2024/0606

284 Carlton Road, Athersley South, Barnsley, S71 2BA

Single storey rear extension and detached double garages.

PRO PLAN & ELEVATIONS

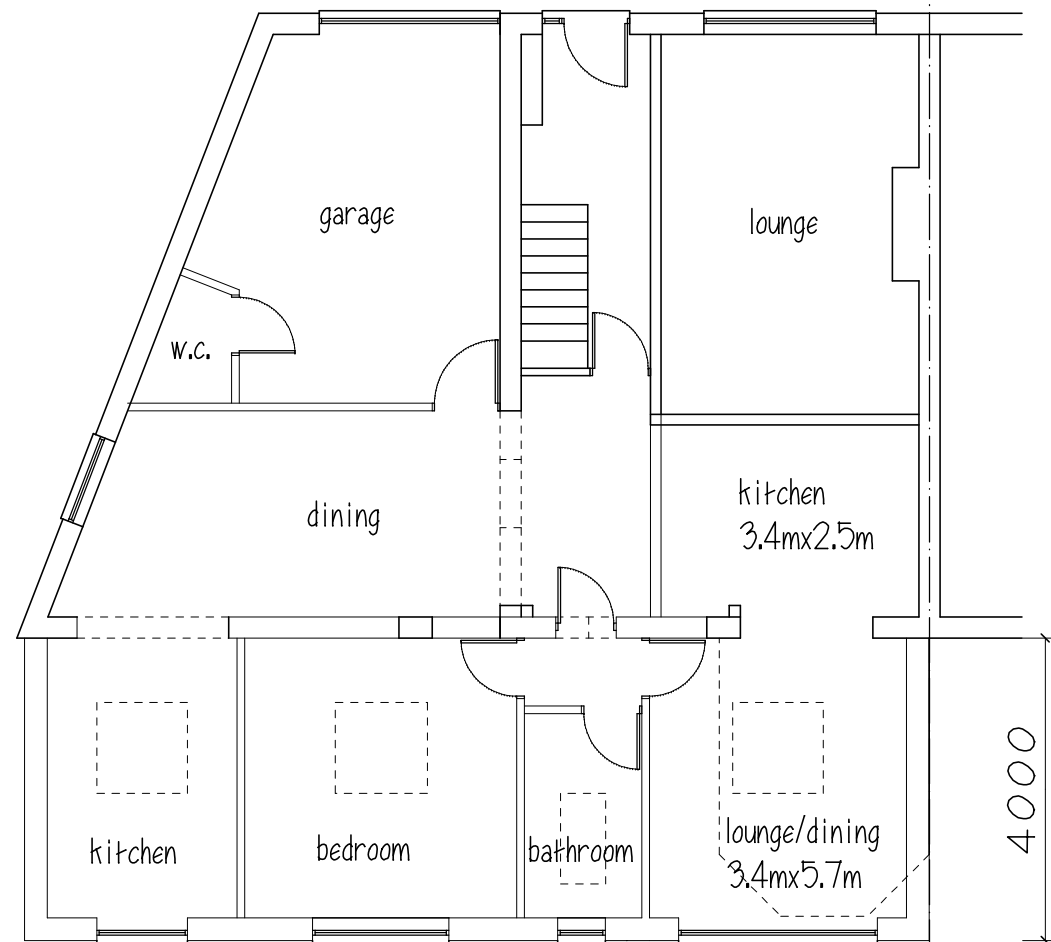
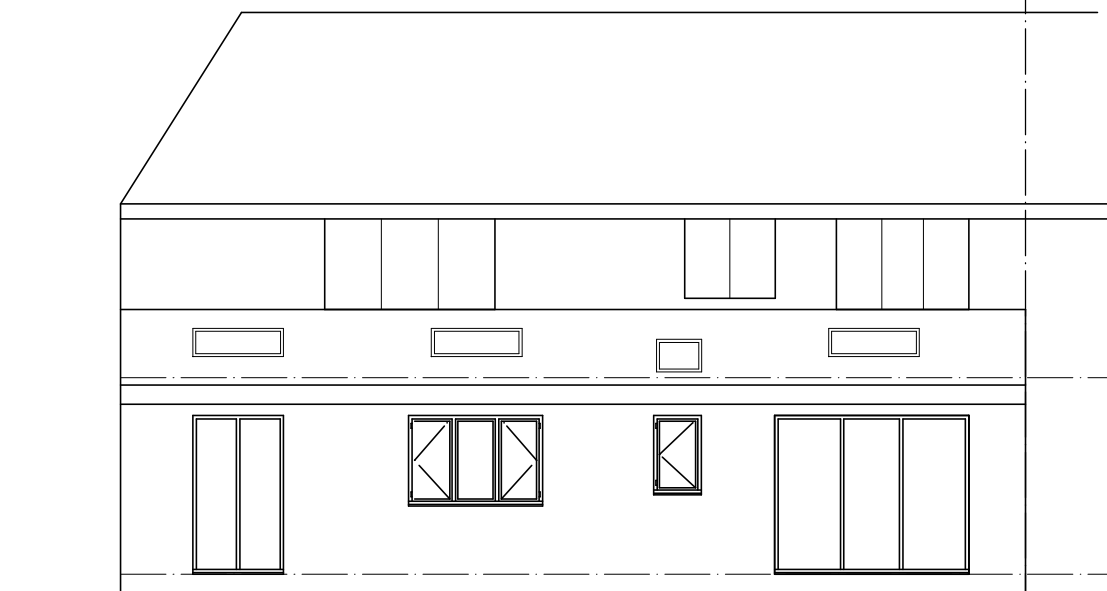
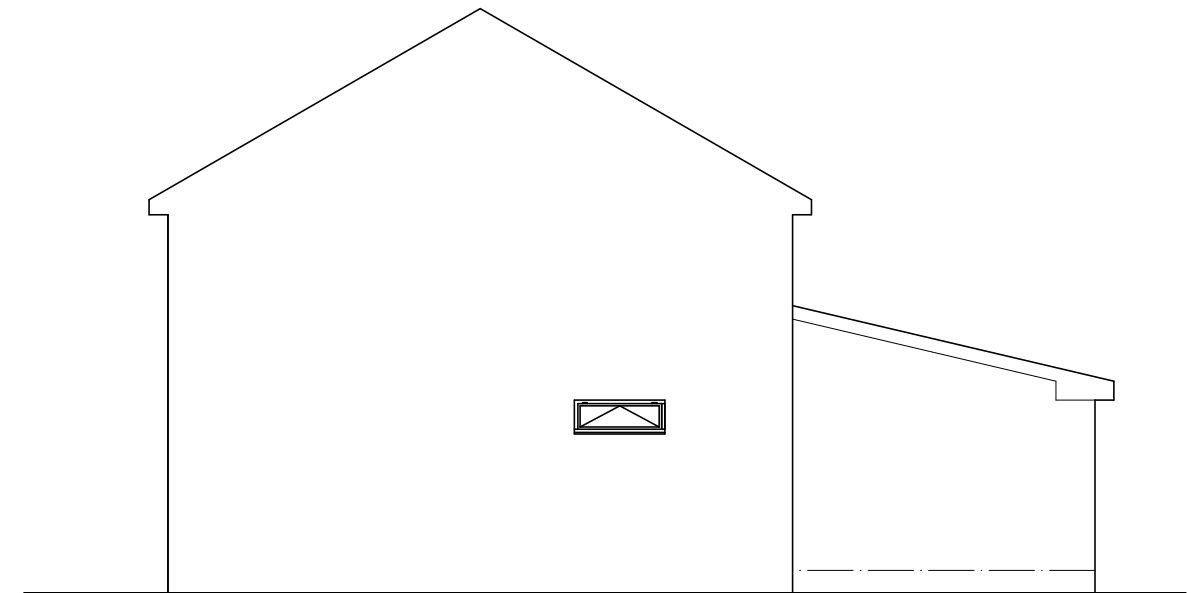
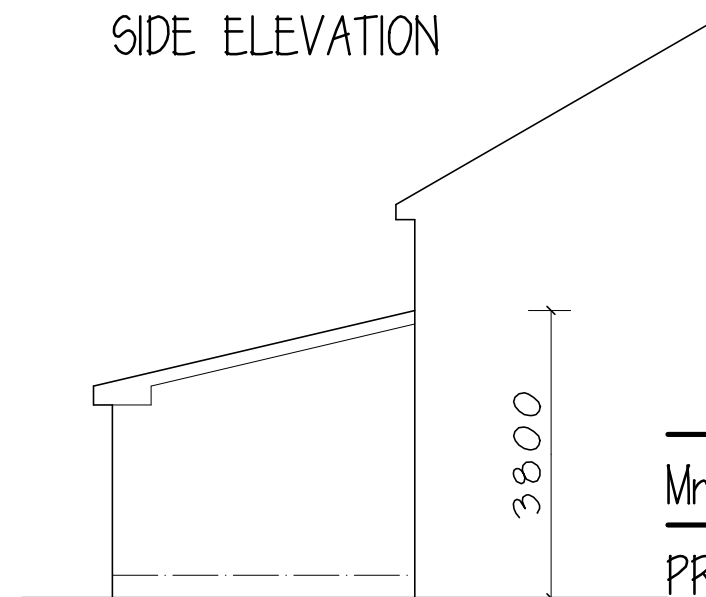
The proposed extension would have a rearward projection of approximately 4 metres with a width of approximately 12 metres. The extension would adopt a mono pitched roof with an approximate eaves and ridge height of 2.9 metres and 3.8 metres respectively. The proposed extension would be constructed of closely matching external materials.

In relation to overshadowing, the proposed extension would be erected to the west of the application property and would be located to the north of adjoining property 282 Carlton Road and to the south of the rear curtilage of adjacent property 286 Carlton Road. The extension would extend the entire width of the extended dwelling and would be built up to the southern party boundary. The extension would exceed the 45-degree rule (which is applied to assess and limit the extent of overshadowing and loss of outlook). However, the extension would be replacing an existing conservatory that abuts the party boundary that has a similar height and reward projection as proposed. A smaller extension could also be erected under permitted development without a requirement for planning permission. Such an extension would also exceed the 45-degree rule. The extension would also be located to the north of the neighbouring property. As such, potentially significantly detrimental overshadowing impacts are likely to be avoided and the amenity of the occupant(s) of 282 Carlton Road would be maintained to a reasonable degree. The occupant(s) of 282 Carlton Road were also notified of the application and no objections were received.

The House Extensions and Other Domestic Alterations SPD states that single storey extension to the rear of semi-detached dwellings should not exceed 4 metres in projection and the eaves height should not exceed 2.5 metres where the extension would project beyond 3 metres. In this instance, the proposed extension would partly comply with this guidance albeit with a higher eaves' height of approximately 2.9 metres. Nevertheless, for the reasons outlined above, the extension is considered acceptable.

In relation to overlooking and loss of privacy, new ground floor windows would be located on the rear elevation of the proposed extension and would face into the application site with a sufficient distance maintained to the rear boundary. A new ground floor window would also be located on the north side elevation of the existing dwelling. This window was reduced in size and positioned high on the wall during the application process which is considered to sufficiently mitigate any potential overlooking and loss of privacy impact.

The proposed extension would not be visible from the surrounding public realm and would not be a prominent feature in the street scene. Nevertheless, the extension would adopt a sympathetic form and features, including a modest scale, a mono pitched roof and closely matching external materials which would comprise brickwork and grey concrete roof tiles.

PRO PLAN & ELEVATIONS

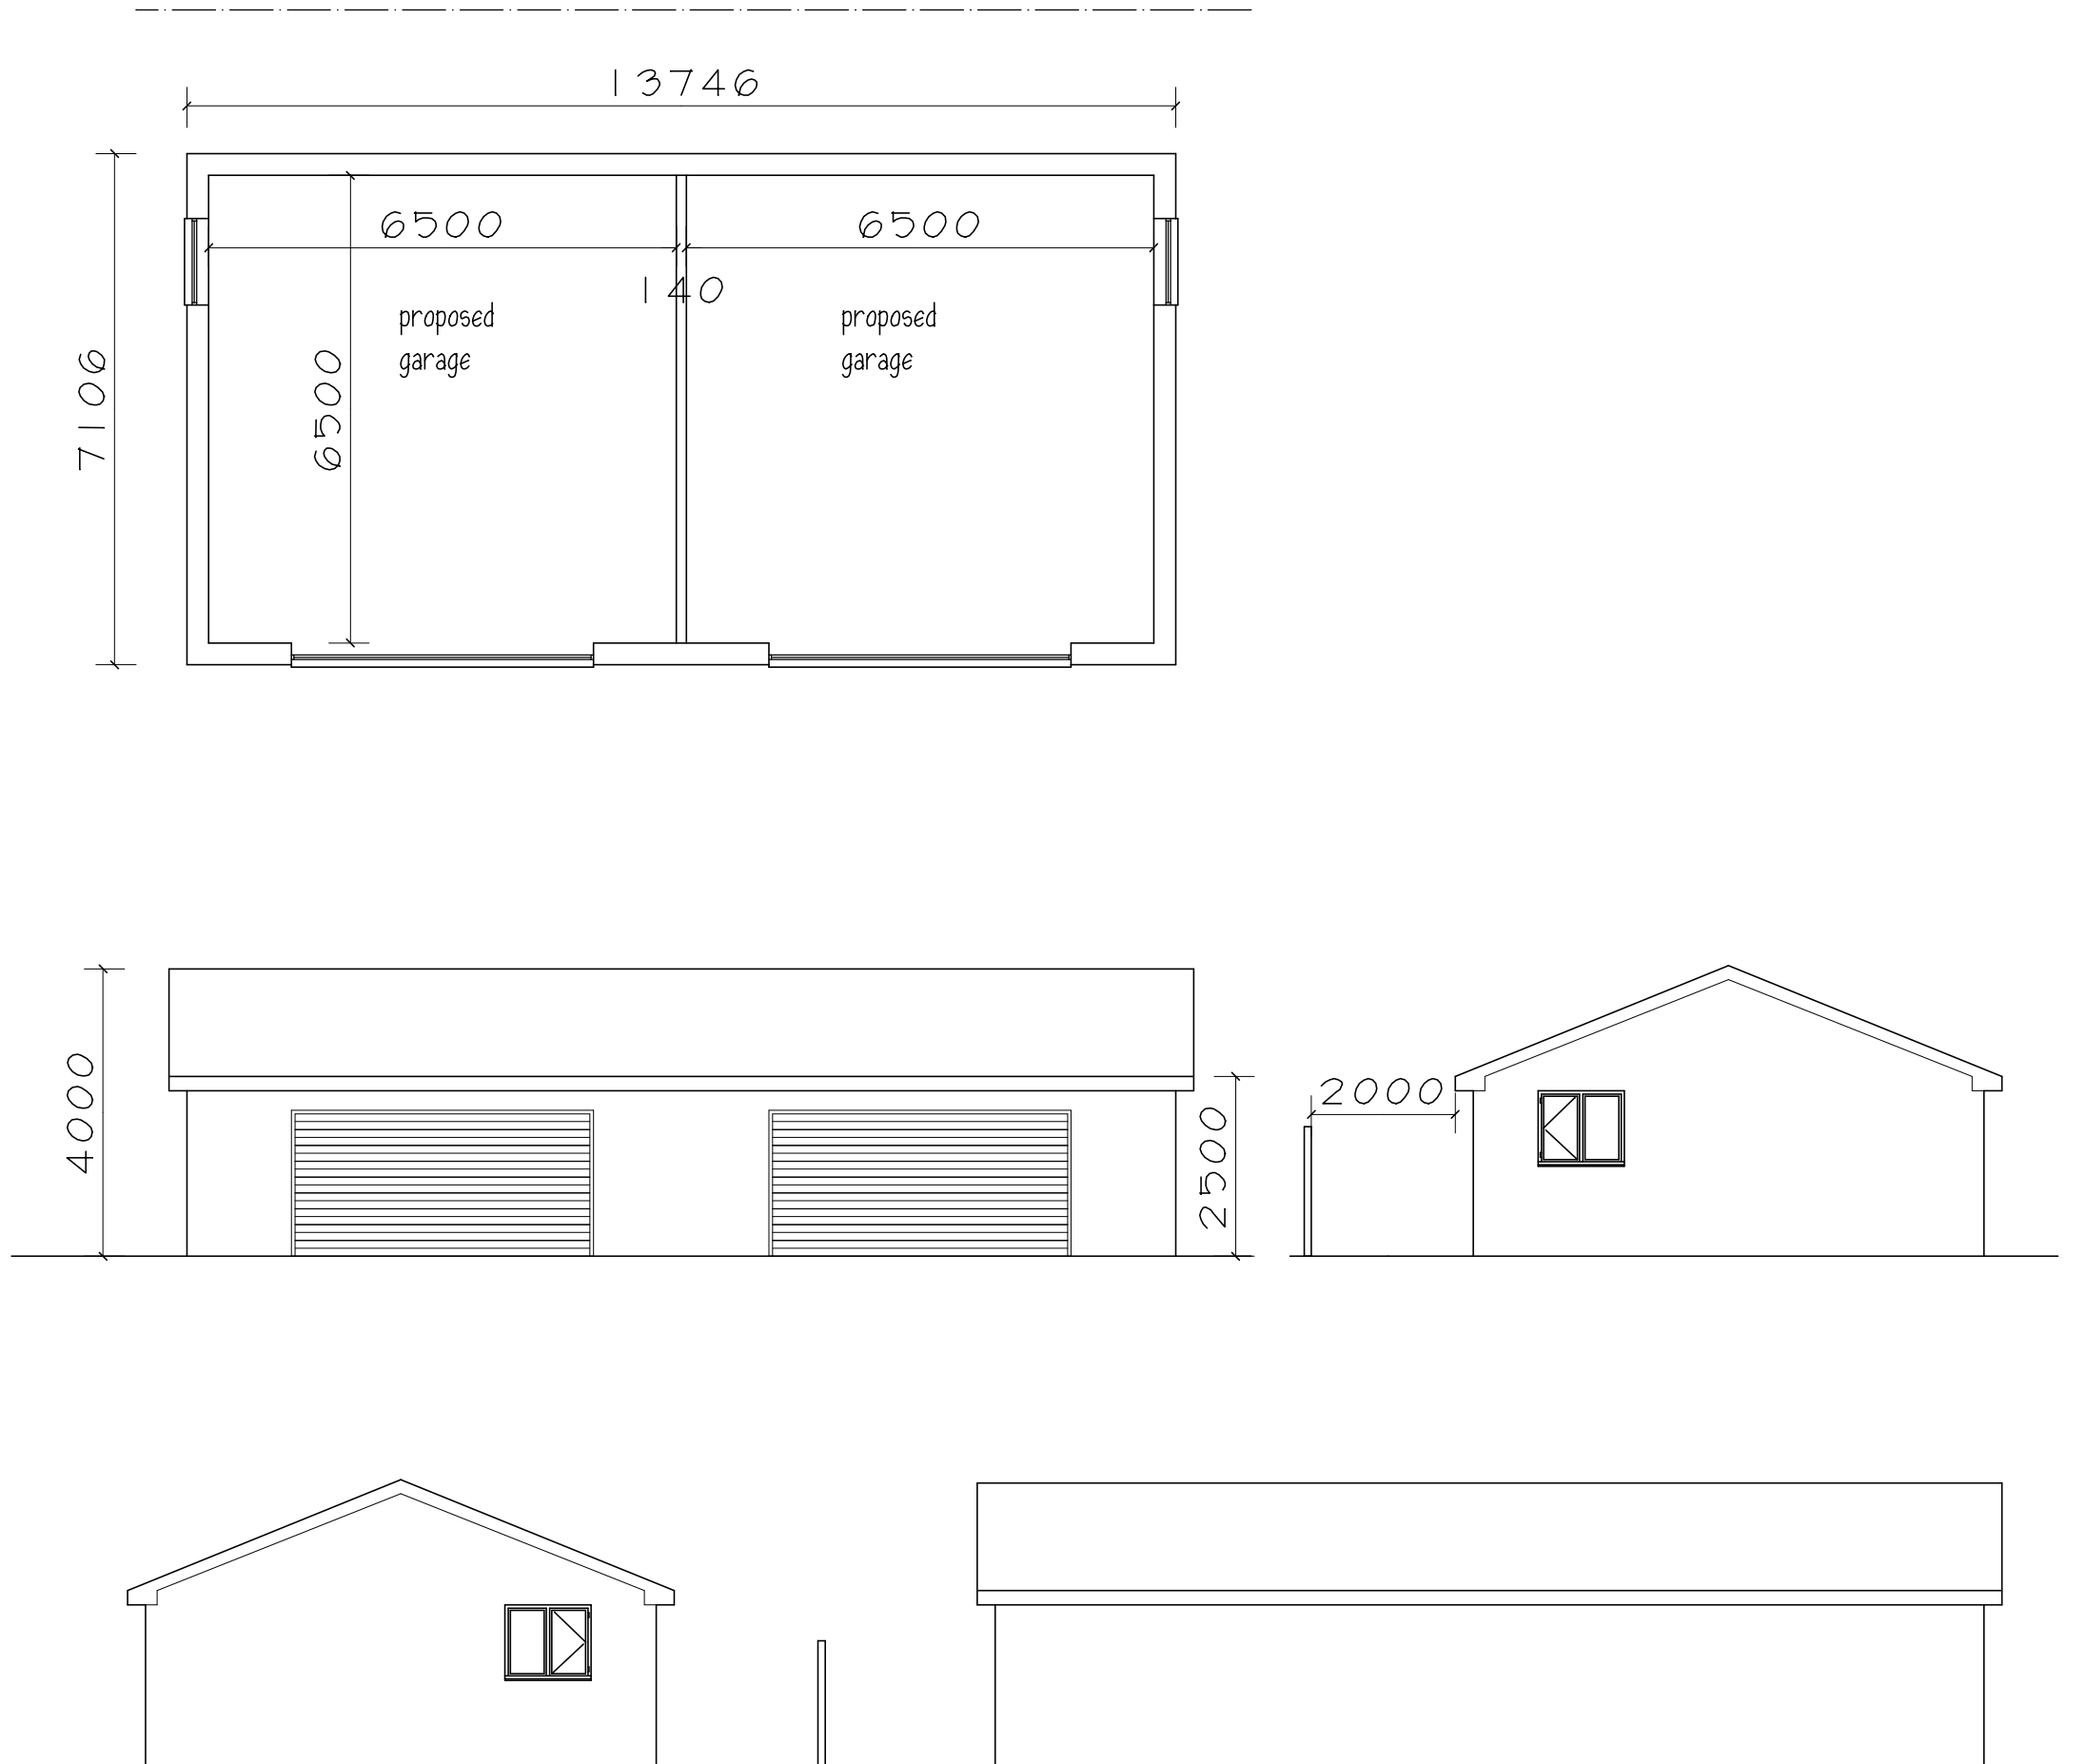
The proposed detached building would measure approximately 13.8 metres by 7.1 metres. The internal measurements of the garages would each measure approximately 6.5 metres by 6.5 metres. The building would adopt a pitched roof with an approximate eaves and ridge height of 2.5 metres and 4 metres respectively and would be constructed of closely matching external materials.

The proposed detached building would be erected to the west within the application plot and would be located to the east of the rear curtilages of 12 Cromford Avenue and 14 Cromford Avenue. The building would be set away from the western party boundary by approximately 2 metres and would adopt an approximate eaves and ridge height of 2.5 metres and 4 metres respectively, in accordance with the House Extensions and Other Domestic Alterations SPD. While some overshadowing could occur, this is likely to be limited to the early morning and not at peak times for use of a rear garden. Existing boundary treatments are also likely to offer some mitigation. While some overshadowing

could occur to the rear curtilage of 286 Carlton Road, a two-metre-high fence could be erected in the location under permitted development and could offer a reasonable level of mitigation.

The proposed detached building would feature one window located on each side elevation which would serve non-habitable spaces. Existing boundary treatments could provide some screening with the potential to erect additional boundary treatments under permitted development if required.

The proposed building would be partially visible from the surrounding public realm. However, the building would be set within the rear curtilage of the application property and away from the highway. The building would therefore not be an overtly prominent or dominant feature in the street scene. The building would adopt a relatively large footprint, but its form and design would generally be sympathetic, including a pitched roof and closely matching external materials comprising brickwork and grey concrete roof tiles.

The proposed detached garages to the rear of the application property would be sufficiently sized to accommodate up to four off-street parking spaces, in accordance with the parking SPD. An existing driveway and a reduced integral garage would also be retained to the front of the application property.
